16850 Stepler Road
Traffic Study Letter
PCD File No.

El Paso County, Colorado

Revise to Traffic
Study Memorandum

Re: 16850 Steppler Road – Traffic Study Letter
El Paso County, Colorado

FIGURE 3
 16850 STEPLER ROAD
 EL PASO COUNTY, COLORADO
 2023 EXISTING TRAFFIC VOLUMES

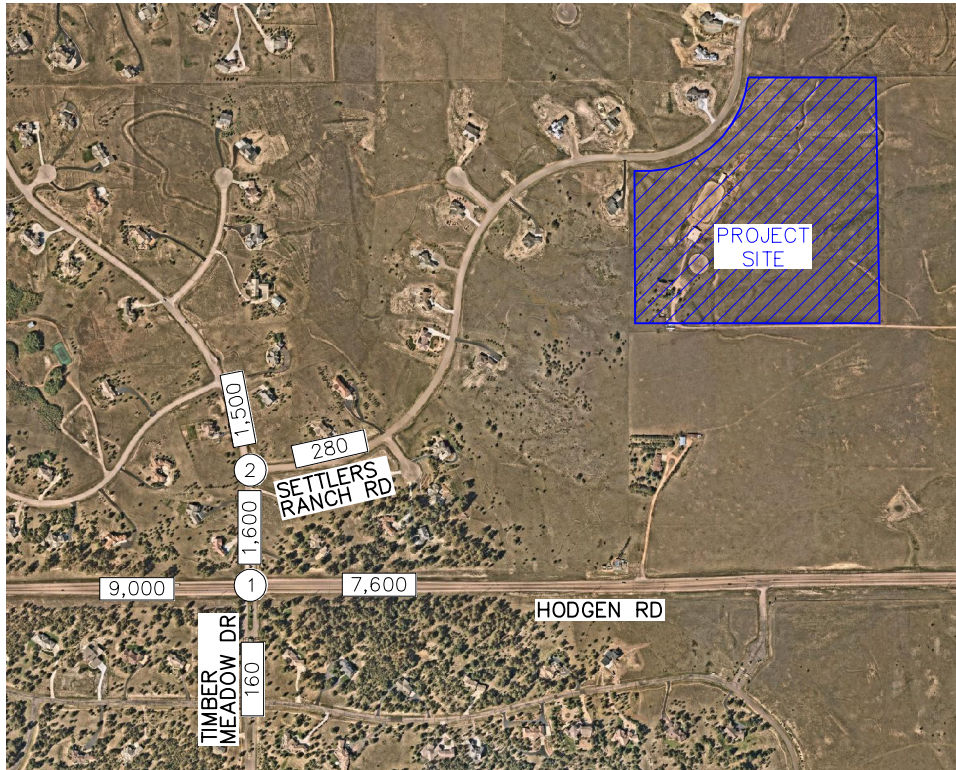
Timber Meadows Drive is a Rural Collector roadway as identified in previous traffic studies by Settlers Ranch subdivision and per the existing 1500 ADT (fig 3). Revise accordingly.

FIGURE 10
 16850 STEPLER ROAD
 EL PASO COUNTY, COLORADO
 2026 TOTAL TRAFFIC VOLUMES

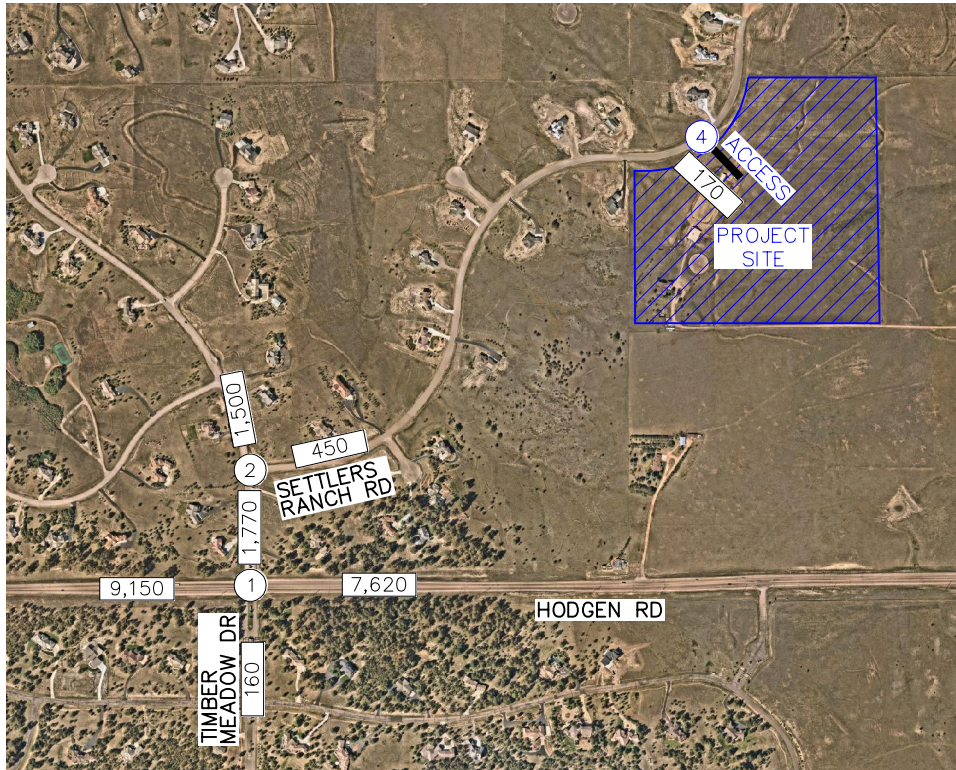
-Provide analysis of turn lane requirements at Timber Meadows and Hodgen. Per the total traffic volumes (figure 7) it appears that the threshold for a southbound dedicated right turn lane on Timber Meadows is met. Provide recommendations whether a dedicated right turn lane should be installed or if the queuing and widen radius that was allowed in the first fillings of Settlers ranch is sufficient. (previous TIS from Settlers Ranch will be uploaded onto EDARP for your use. See page 2 #7)
